Development Facilitation Team (DFT) – Review Comments

Project No: PR-2022-007103 Date: 07/10/2024 Agenda Item: #1 Zone Atlas Page: M-14

Request: Final EPC sign-off for Love's Sunport development, Loves Travel Center

Application For: SI-2024-00922 – EPC FINAL SIGN-OFF

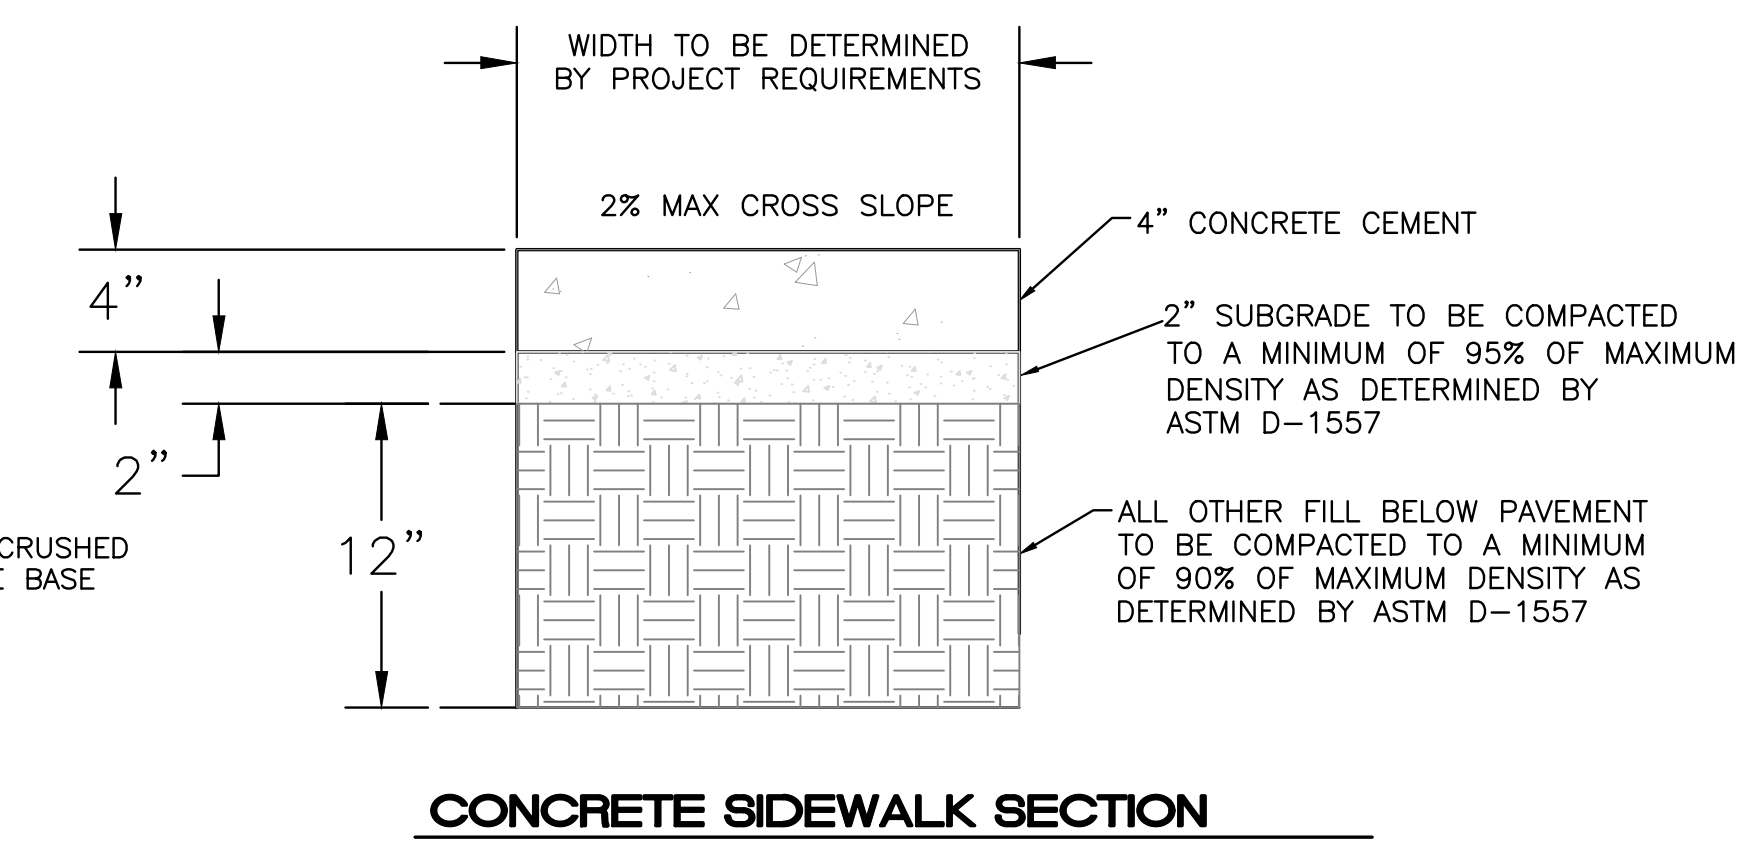
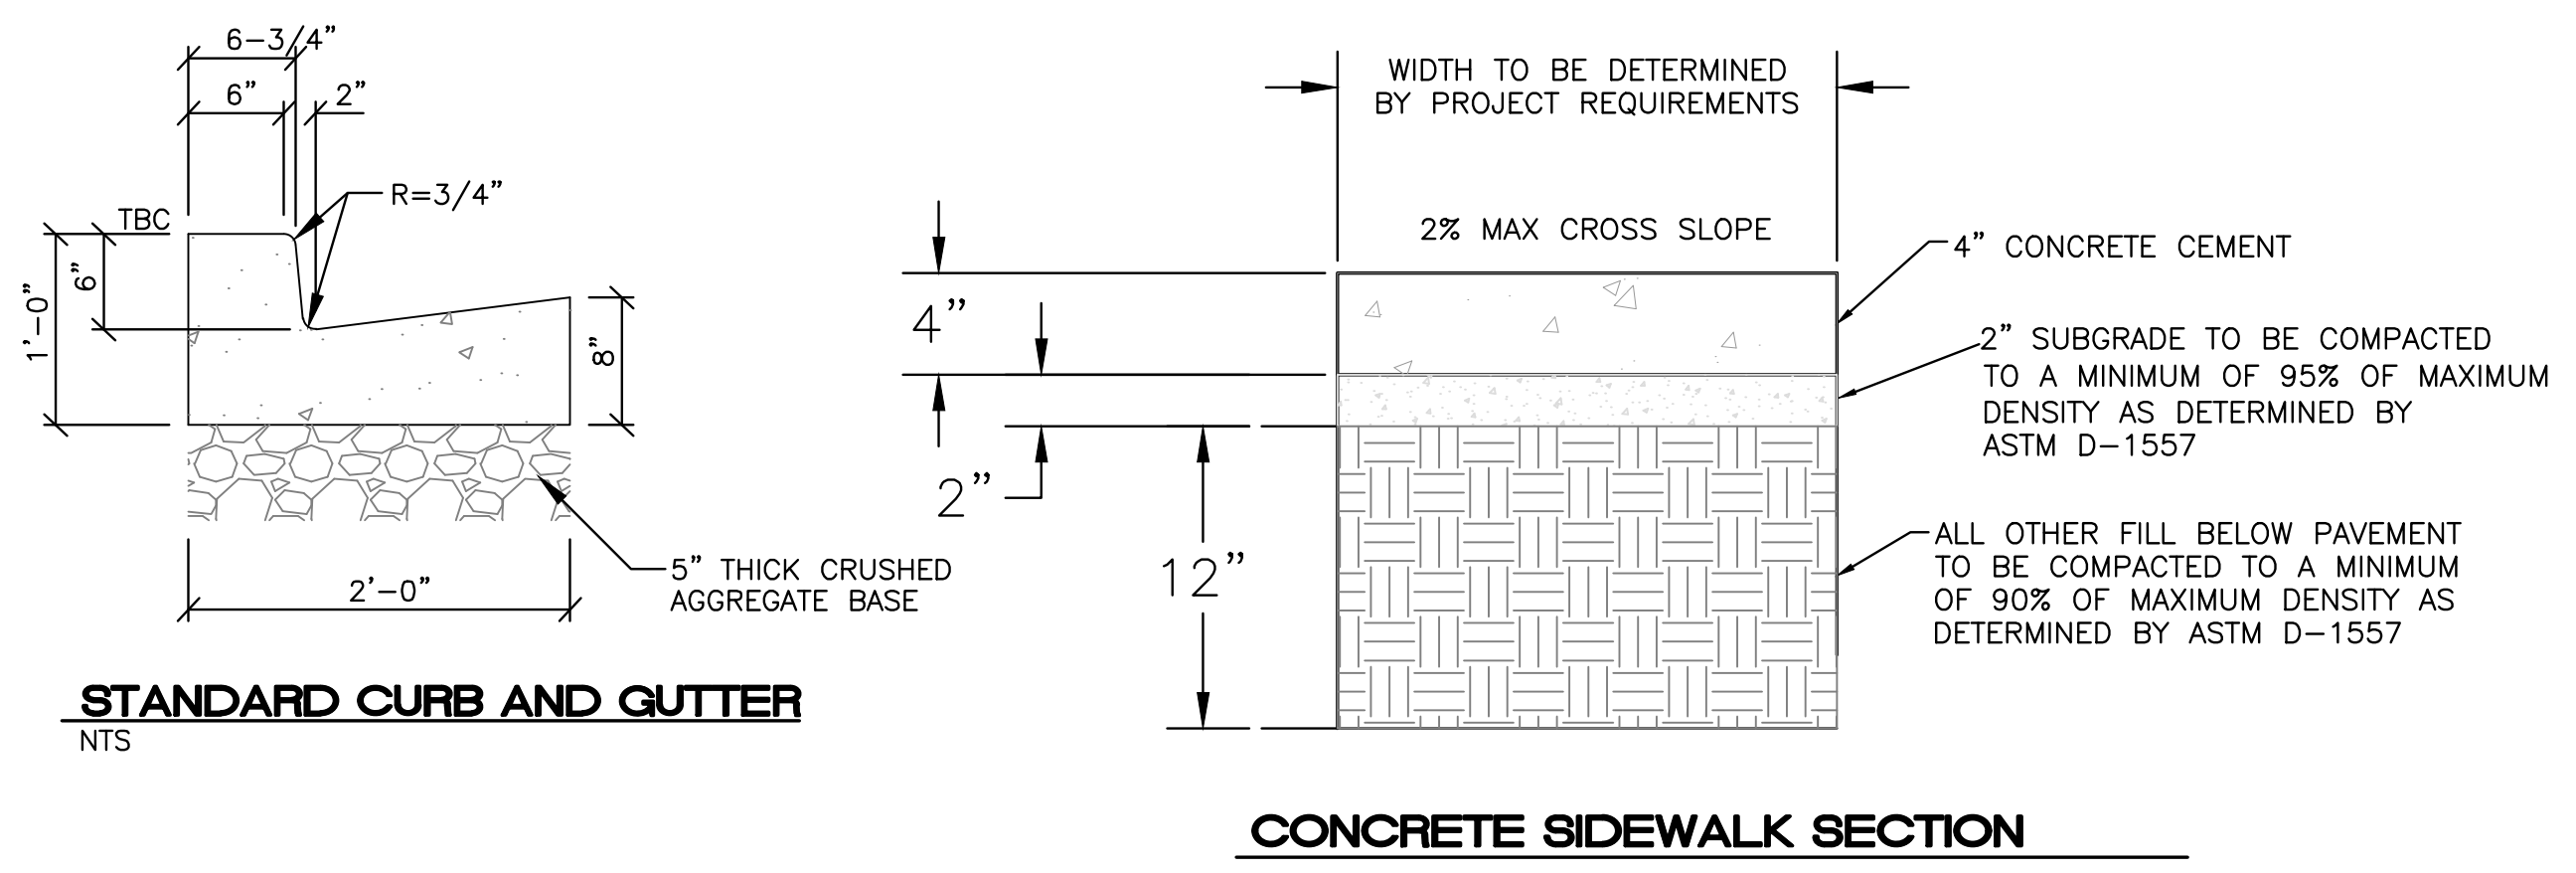
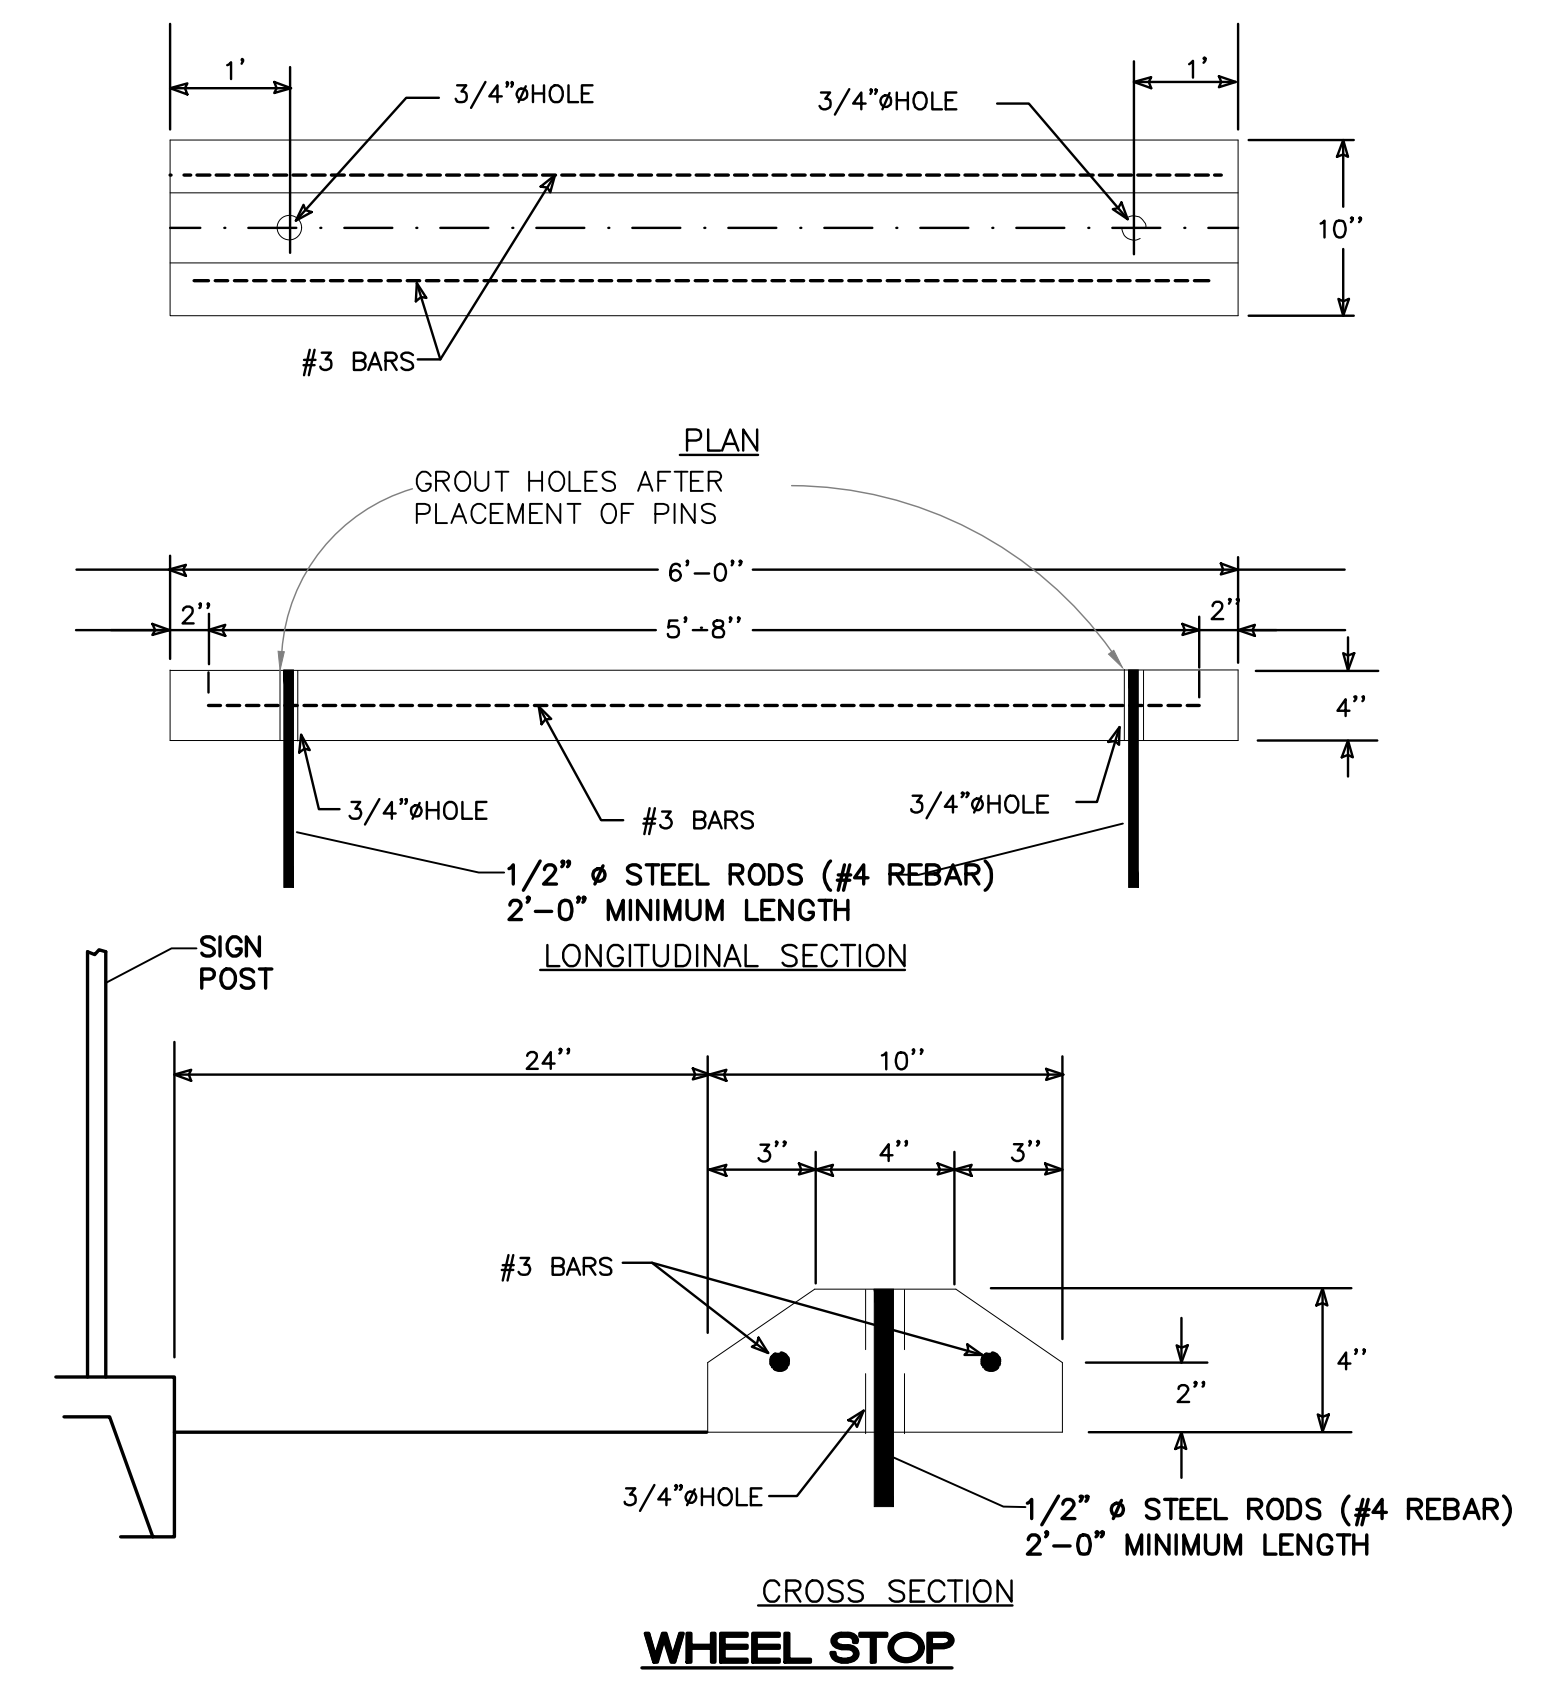
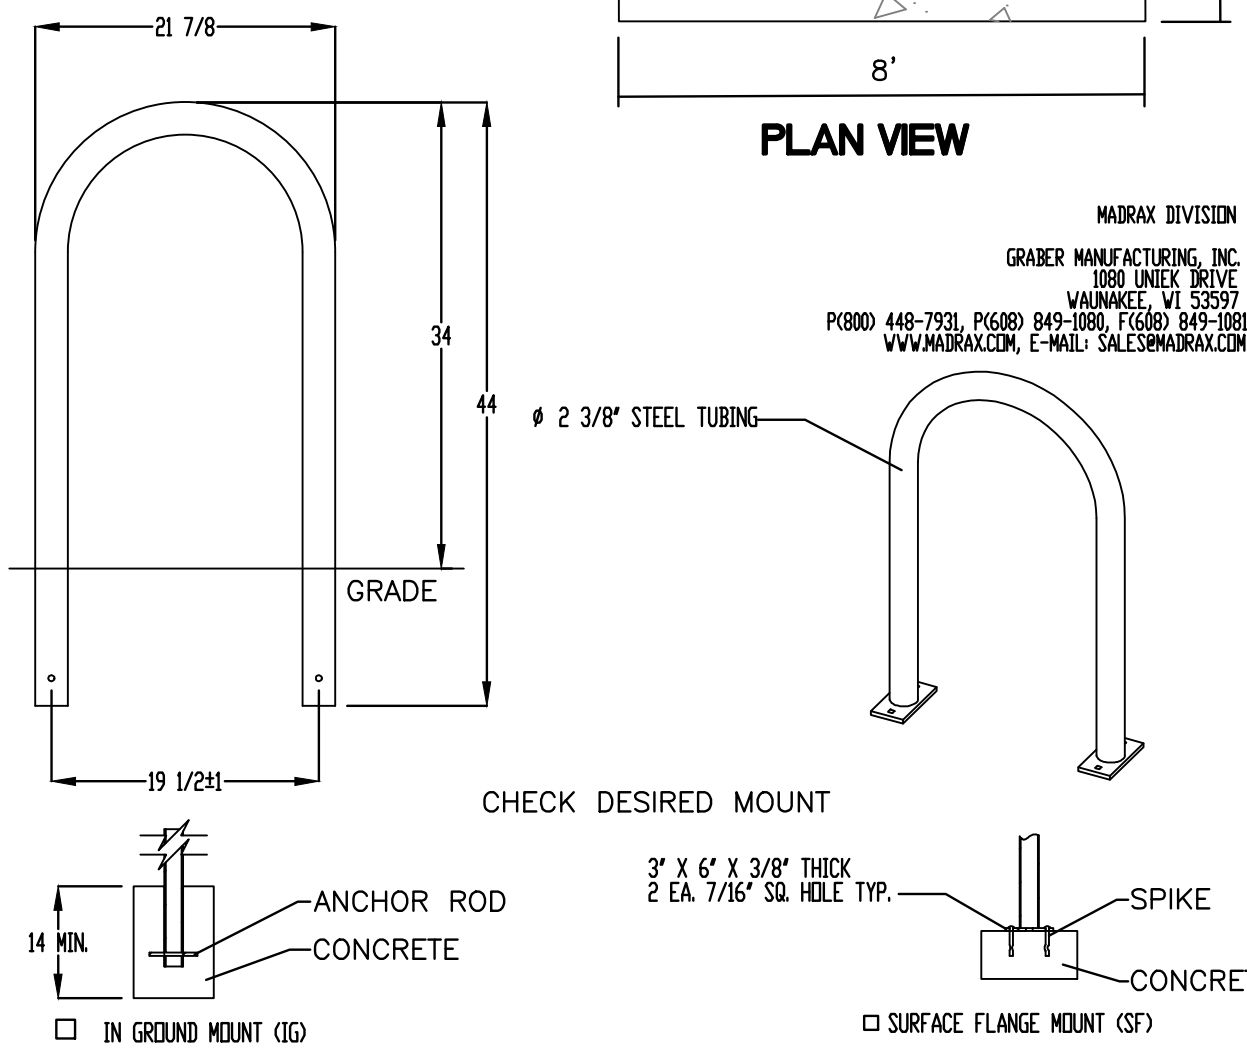
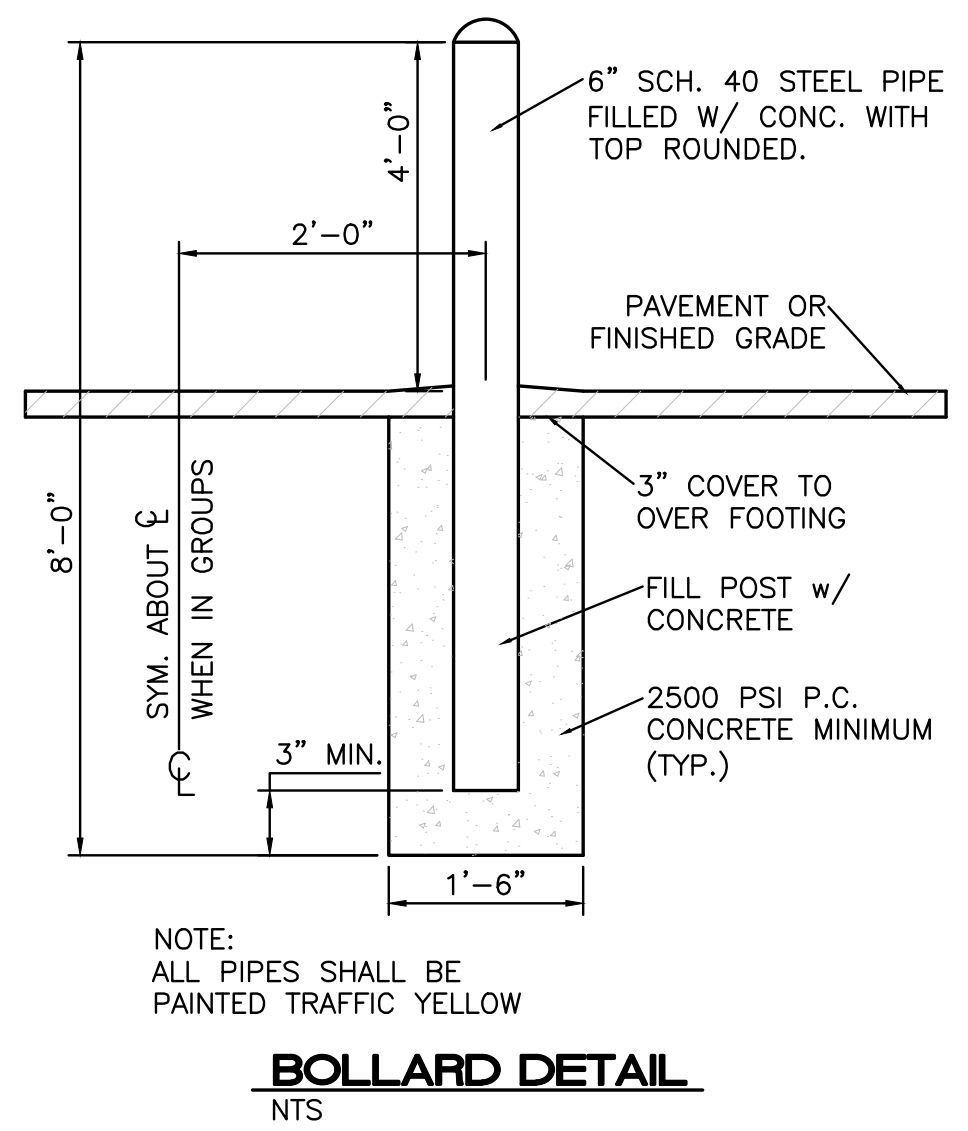
6. Light poles are limited in height to 30 feet in the (non-residential zone districts (NR-LM), as per IDO 5-8(D)(3), Table 5-8-1. Please correct note on sheet SP-2, Travel Center Site Plan, and related detail plans on sheet DET-1.

SHEET DET-1: See excerpt from details shown on next page, indicating height of 40 feet.

- Confirm all Use Specific Standards are being met. Clarify how each is demonstrated within the submittal.
Confirmed
- Clarify lighting height. Plan elevation measurement is not shown from finished grade.
See light pole detail on DET-1 plan sheet. 30' max height shown from finish grade

light pole callout revised to reflect 30' max height on plan and detail sheet DET-1

light pole callout revised to reflect 30' max height on plan and detail sheet DET-1
